Reference Planning Application Number R/302/18/HH

First floor extensions to front, side and rear elevations, conversion of roof space to habitable use, including raising of ridge height and front and rear dormers -
16 Meadway, Rustington, BN16 2DD

Drawing Title:
Proposed Plans, Elevations, Roof Plan and Site Block Plan

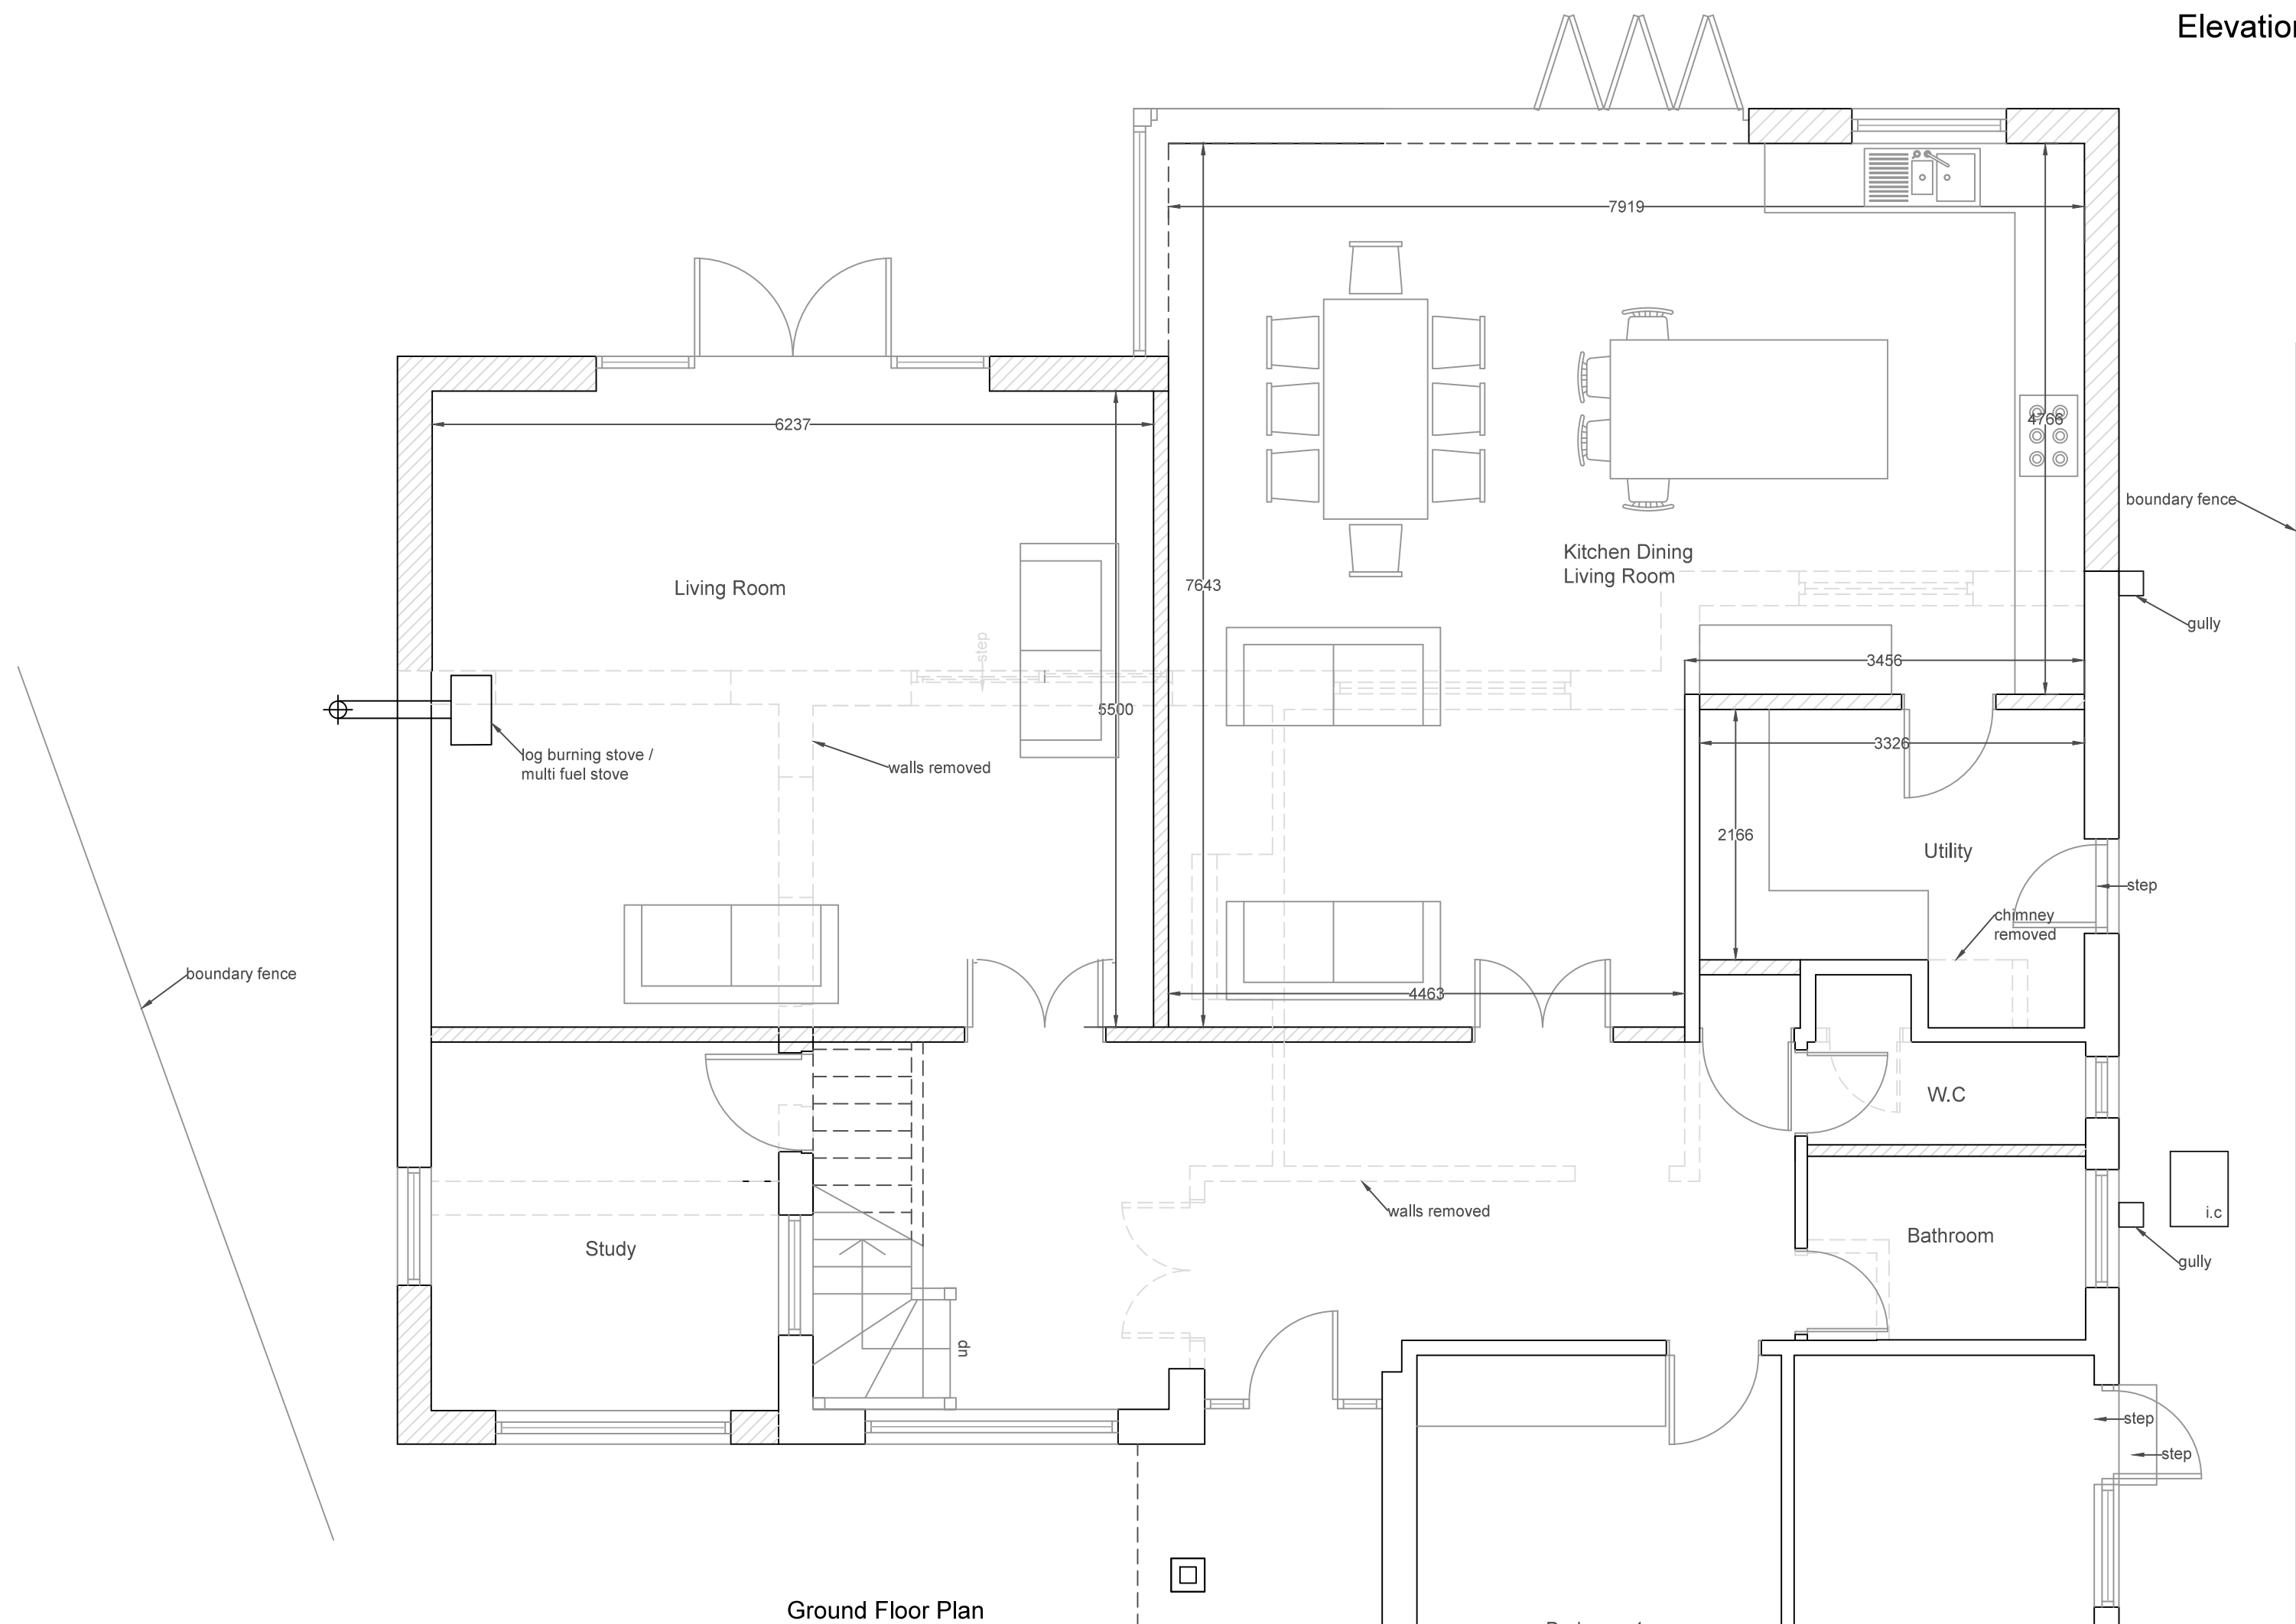
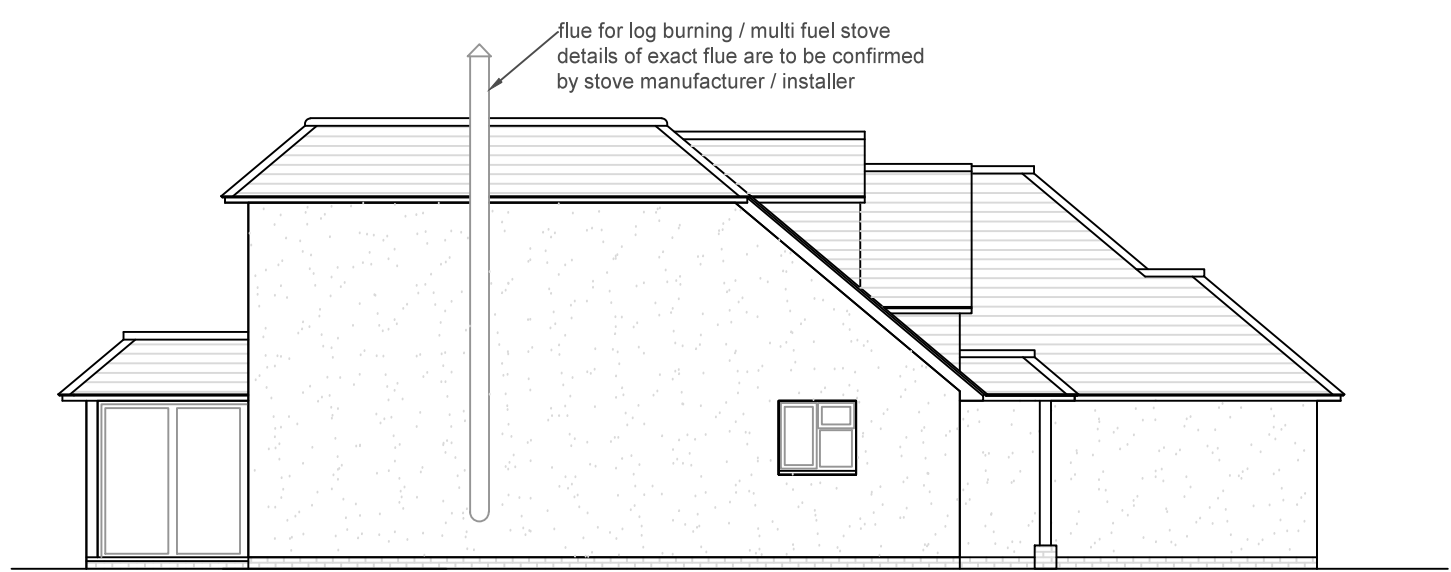
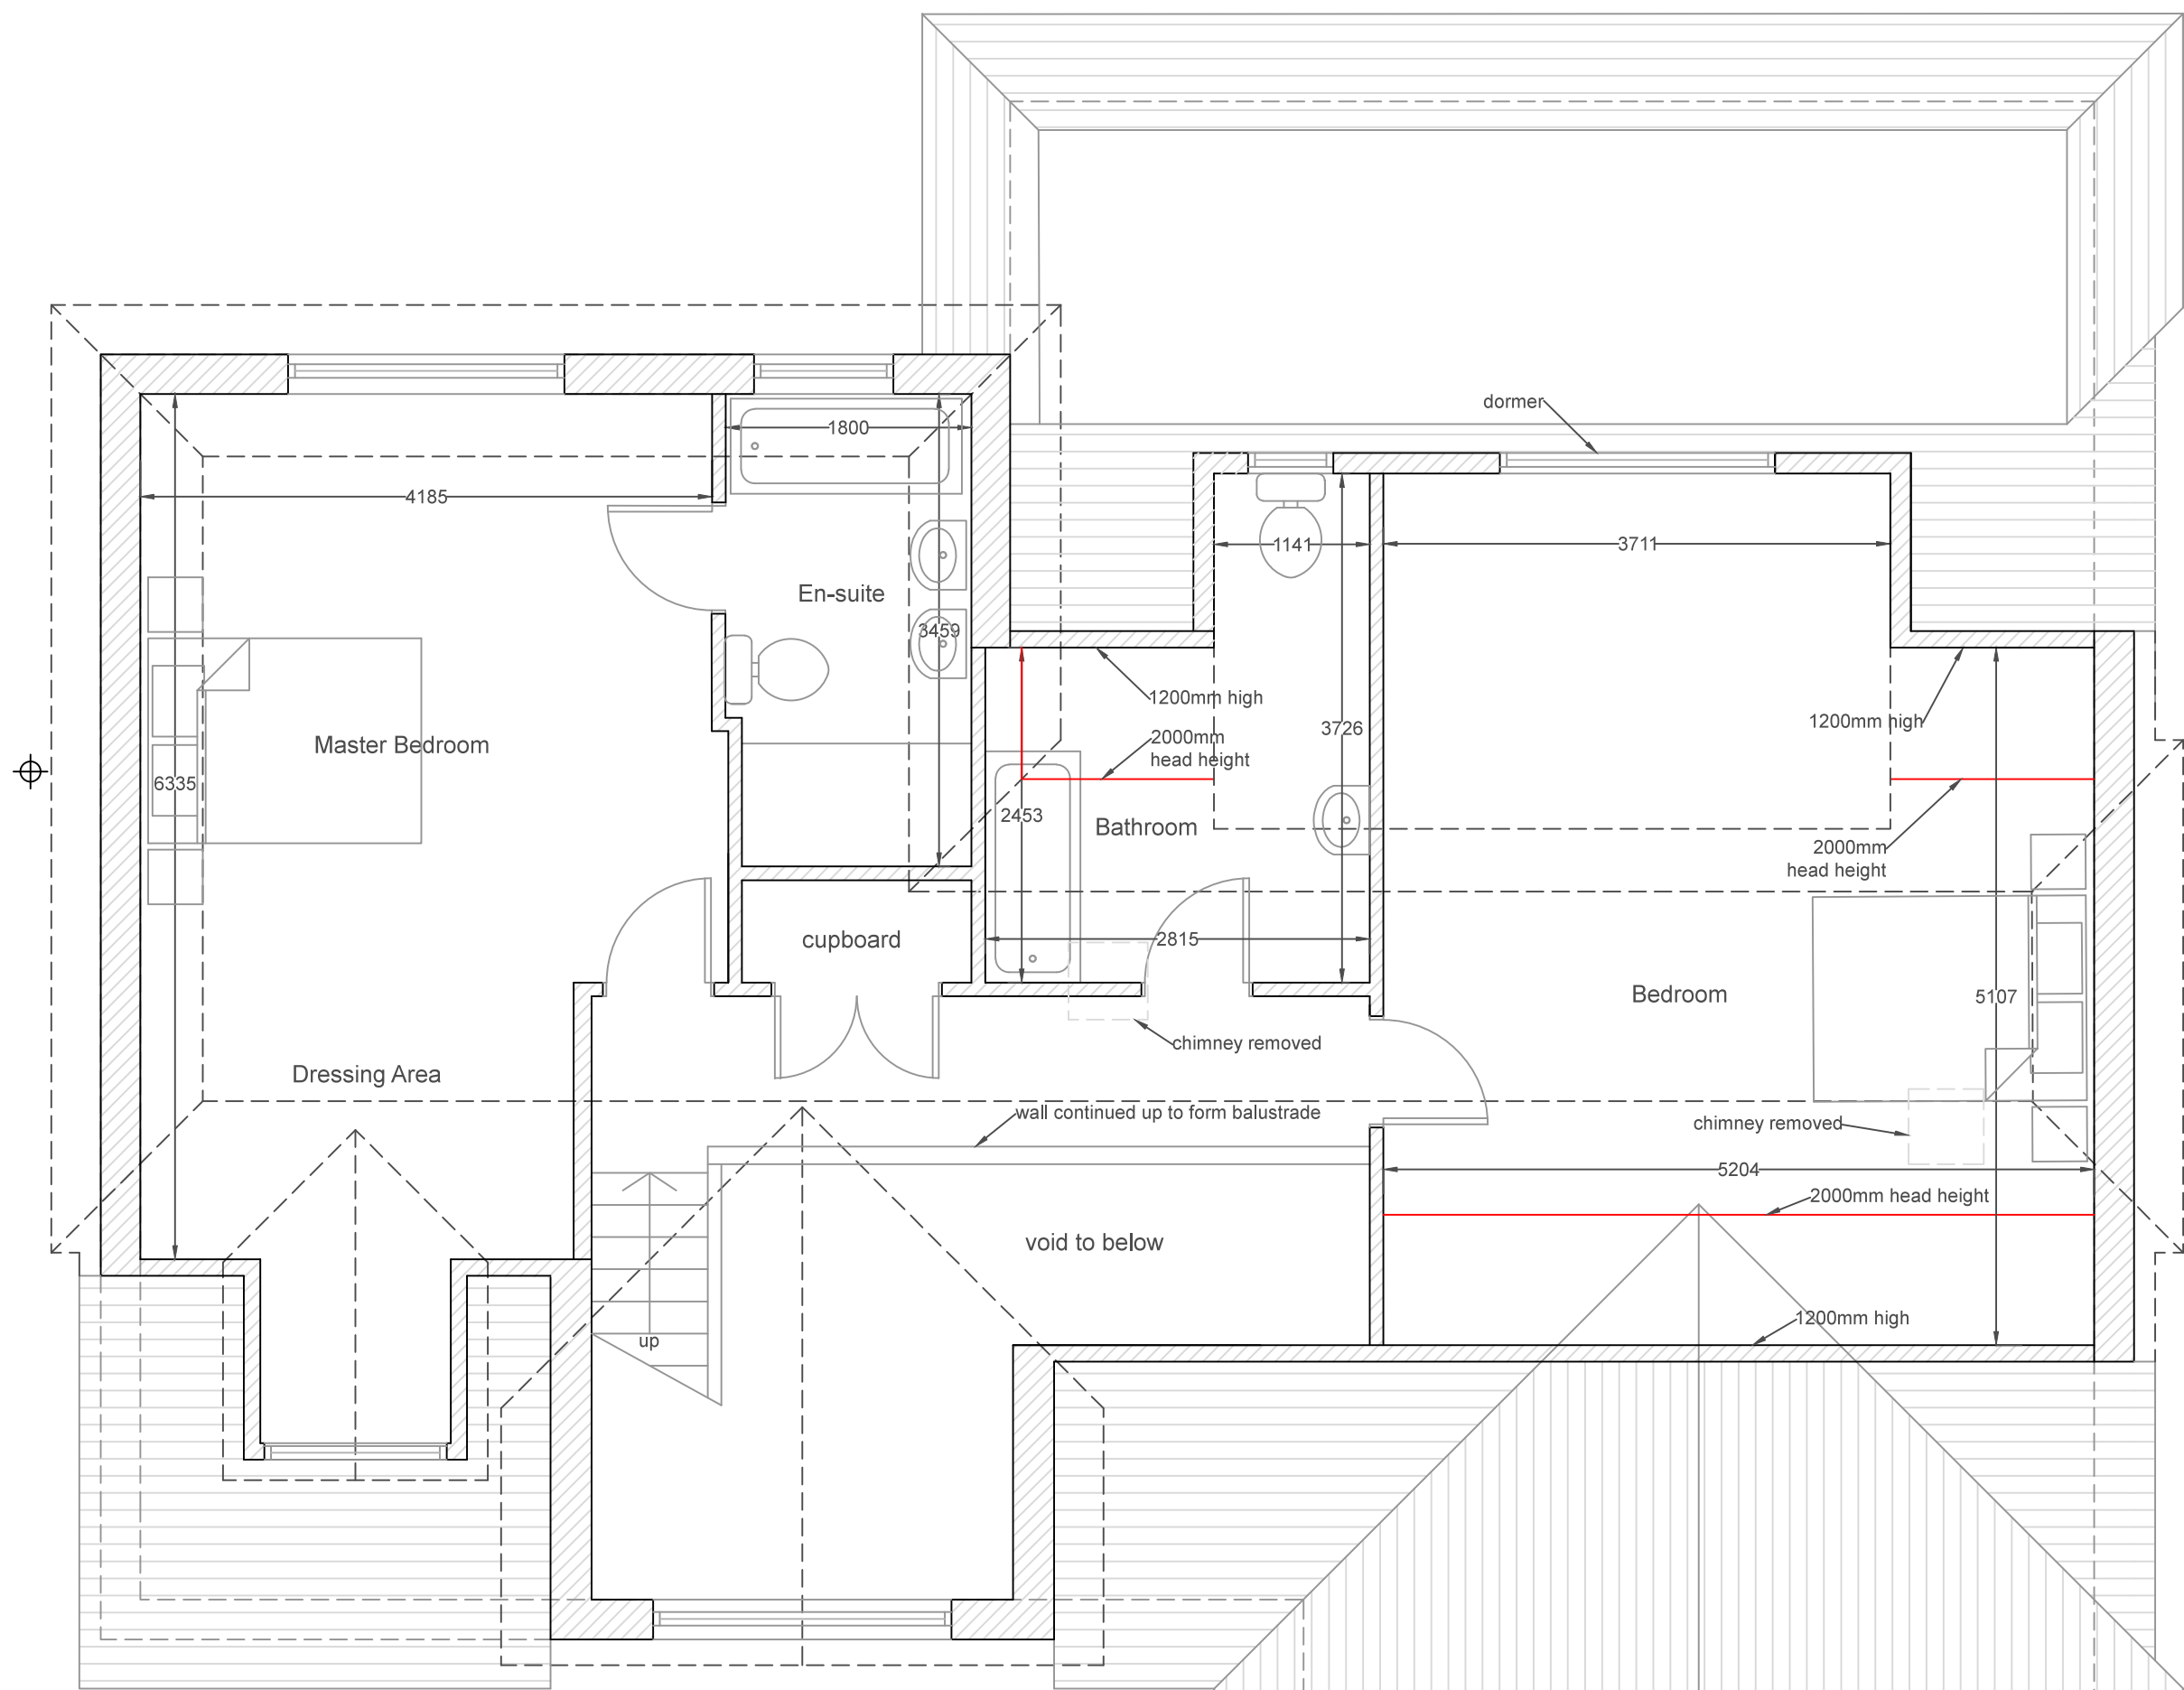
3. **Have ground and first floor extensions where the proposed building line/footprint to the side and rear are out of alignment with existing neighbouring properties 'Nos. 14 and 18'. The bulk of the extended side walls would therefore adversely affect the residential amenity of neighbouring properties 'Nos. 14 and 18'.**

The bulky size of the extensions, on the ground and first floor, to the side and rear of the proposed house at 'No. 16', would significantly extend beyond 'No. 16's' existing footprint, and beyond the existing rear single storey building lines of 'Nos. 14 and 18'. Because of this 'Nos. 14 and 18' would both be faced with a two storey solid brick side wall where at the moment there are no walls.

4. **Overlook properties 'Nos. 14 and 18' with loss of privacy**

Once again the proposed house at 'No 16' would have a big negative impact on the two adjacent properties, namely 'Nos. 14 and 18' in particular! At the moment the gardens of 'Nos. 14 and 18' are not overlooked by windows of neighbouring properties! However if the proposed development of 'No. 16' is completed 'four' first floor rear windows, on the west side, would overlook the gardens of 'Nos. 14 and 18' and the residents of 'Nos. 14 and 18' would therefore be overlooked and lose their privacy!!
